Your Ref: OWPC4282
Our Ref: FP/189/14/PL 17-10-2014
Please ask for:
Mr S Davis

Change of use of car port to covered storage area and new fence to enclose from adjoining car port.

10 Cosens Way Felpham

Detailed Proposed Floor Plan

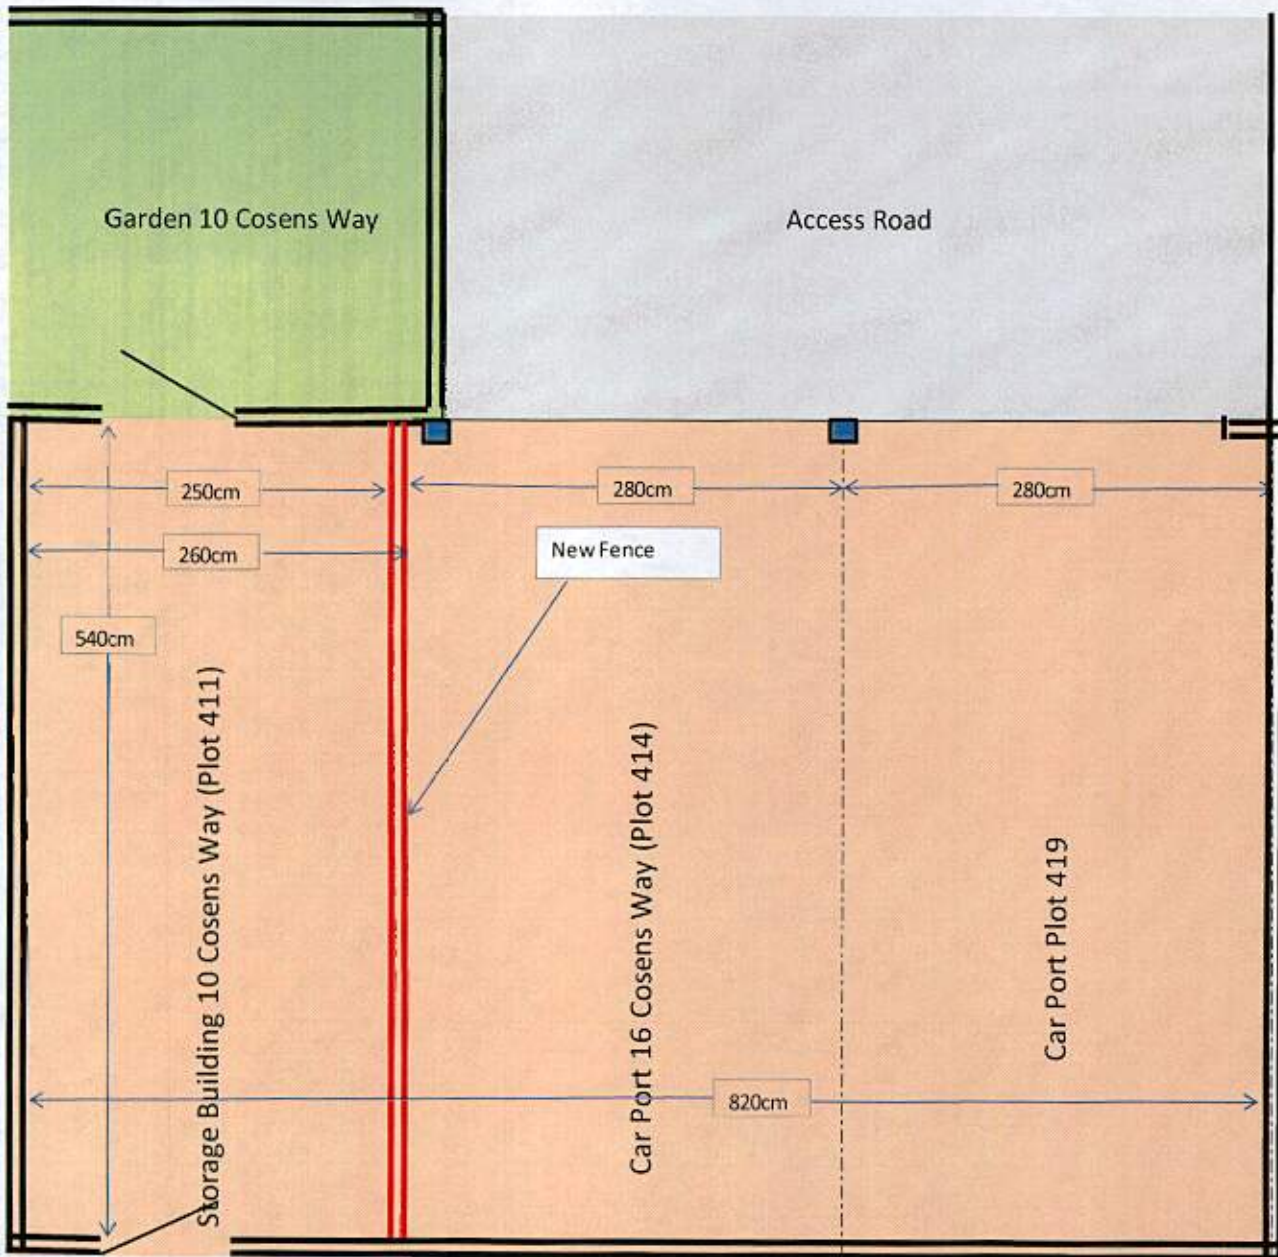
This is my car port and building a fence or wall will inhibit my entering/exiting my vehicle. I bought my house with a port, not an enclosed area. This is a Bovis walkway only.
